Bonhams Field Main Road Yapton BN18 0DX

Y/63/19/RES

Approval of reserved matters following the grant of Y/1/17/OUT for 56 No. dwellings with associated open space & creation of new access. This application affects the character & appearance of the Yapton (Main Road) Conservation Area & affects the setting of listed buildings.

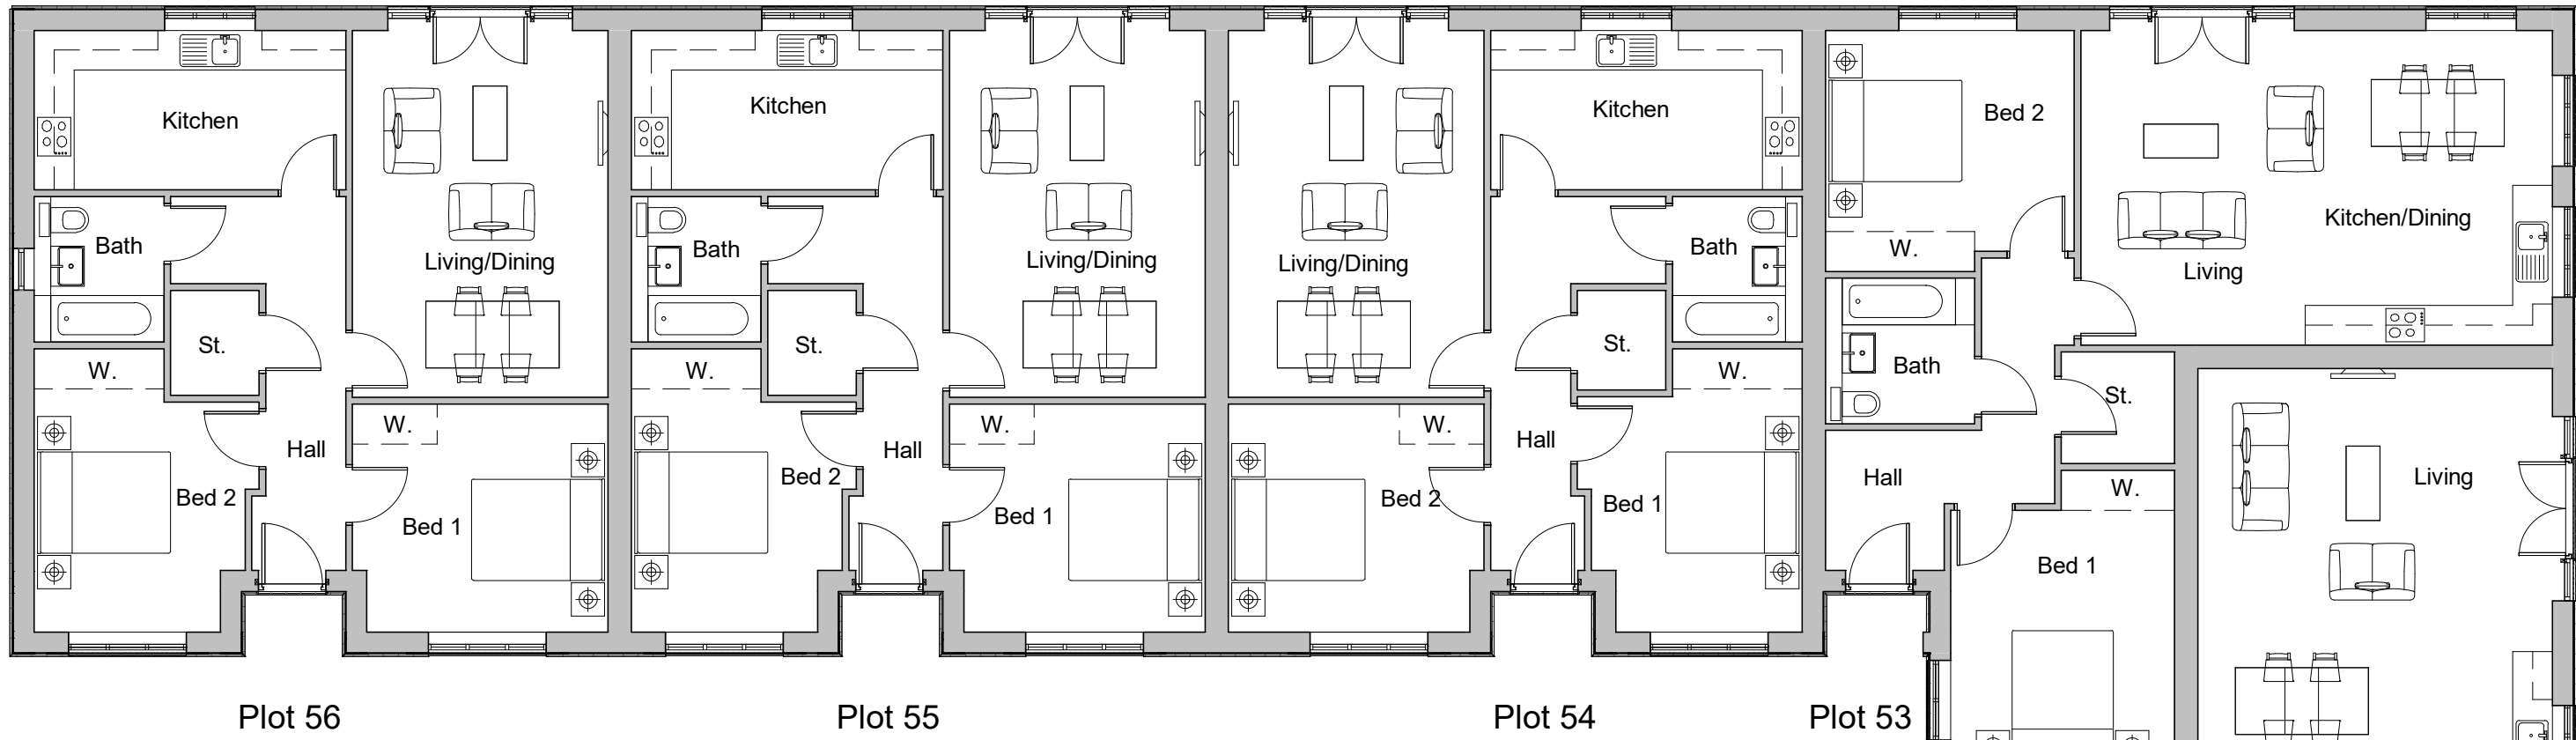
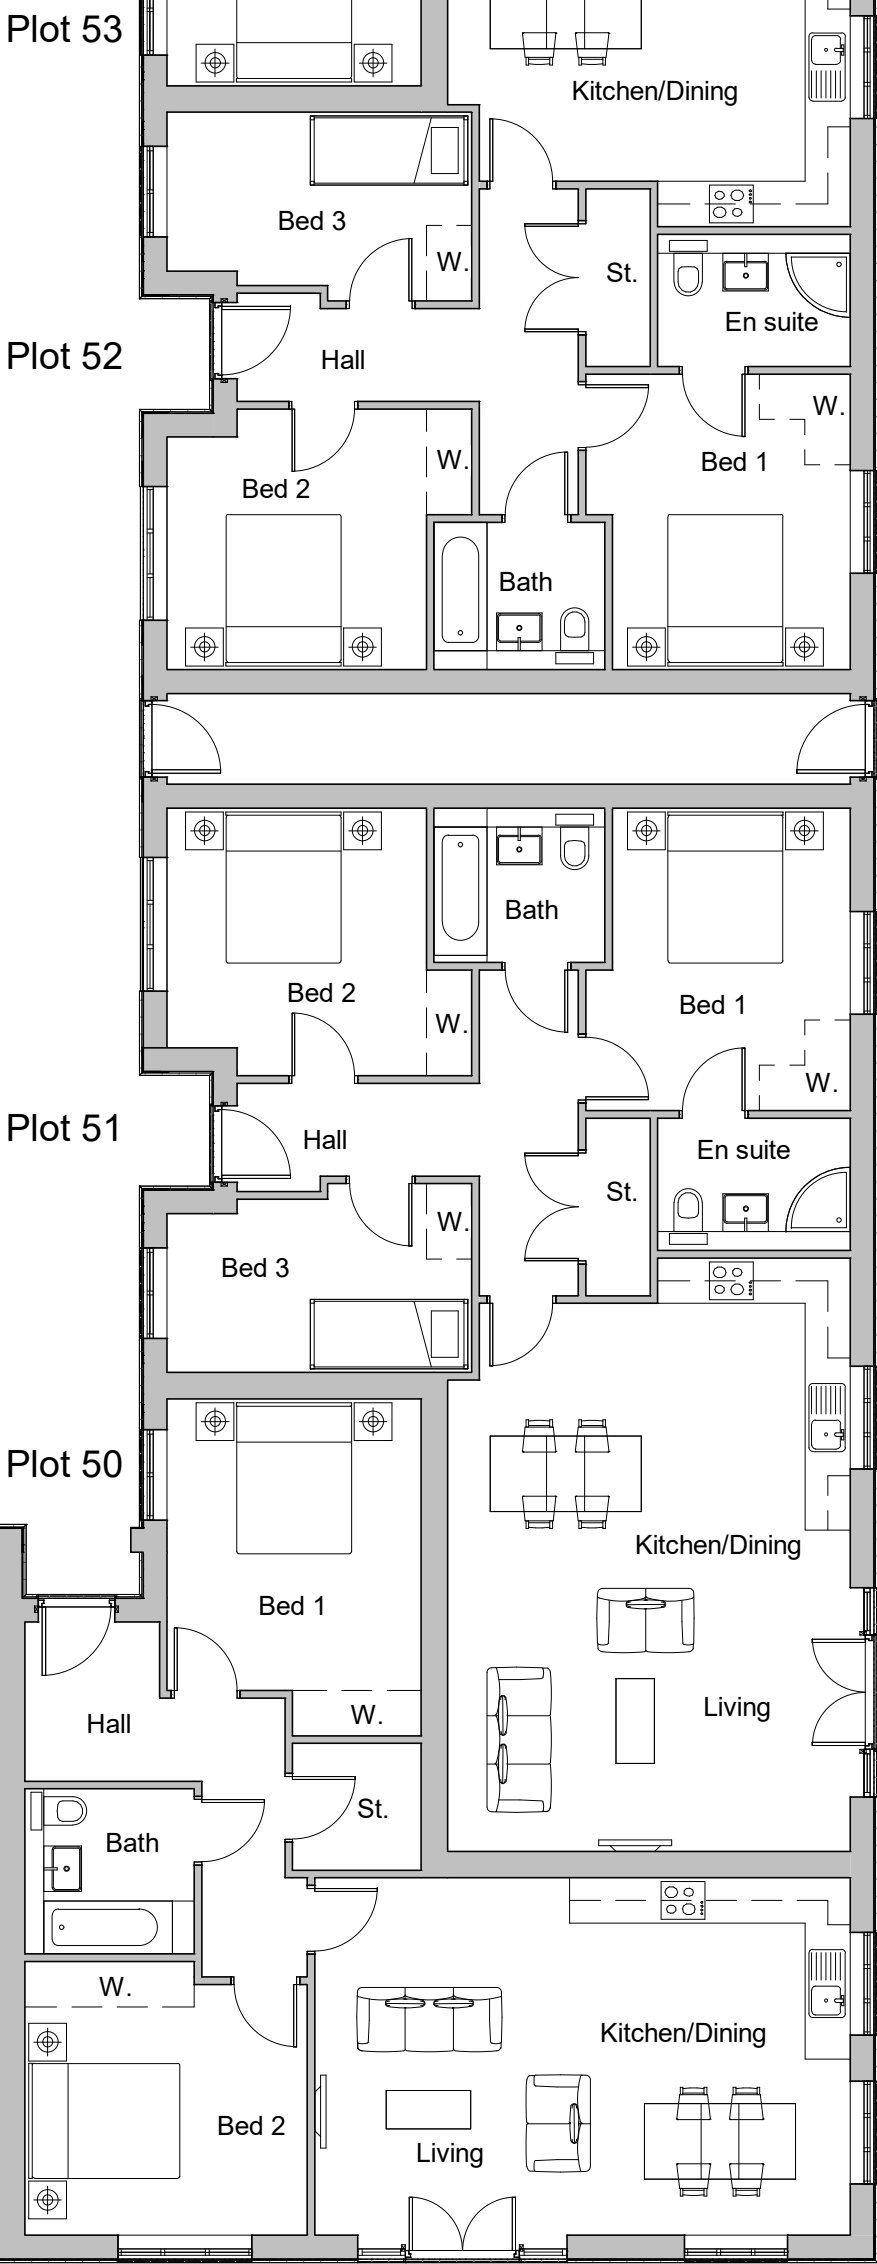
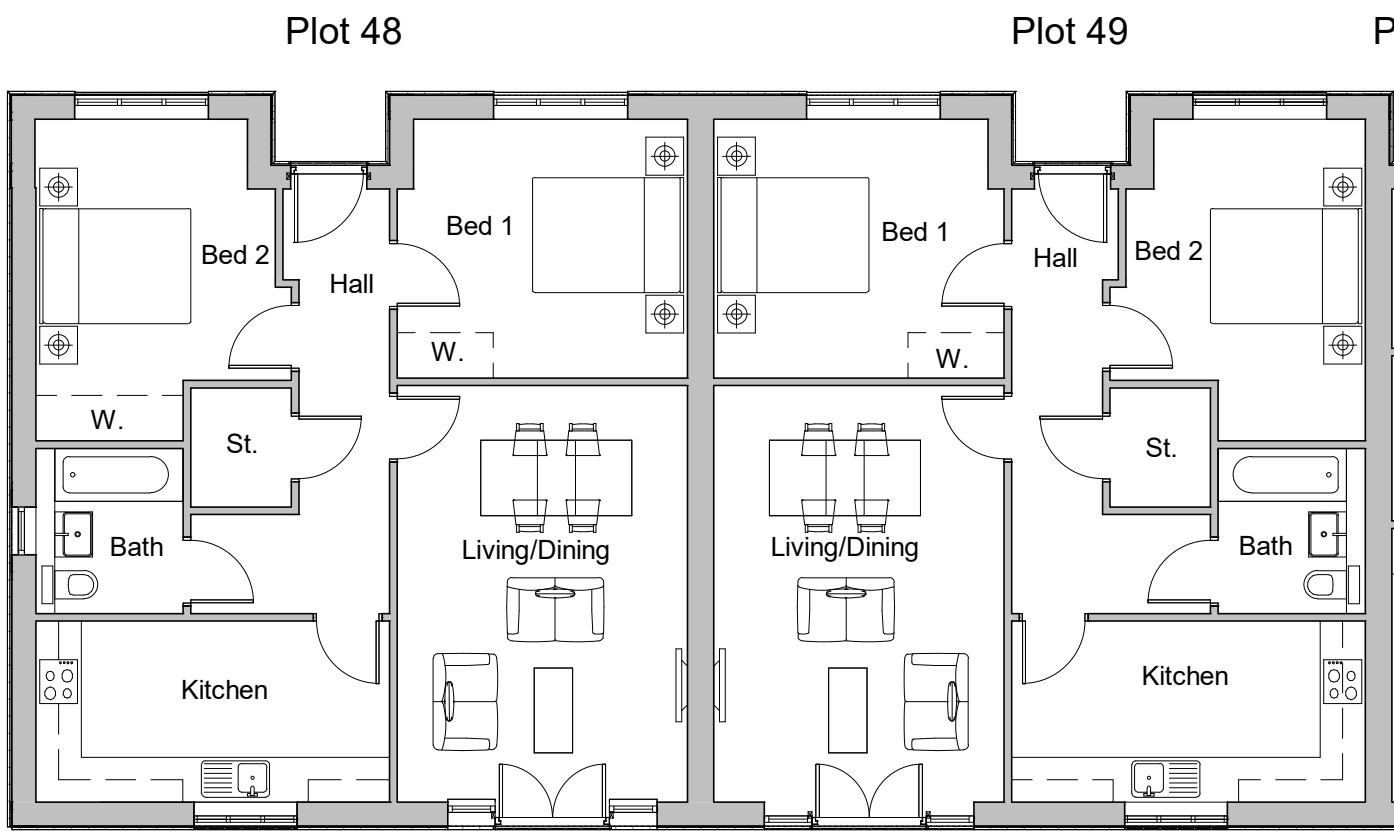
YPC welcome single storey dwellings and would seek a condition that ensures that some are prioritised to older occupiers to help generate the recycling of existing housing stock within the village.
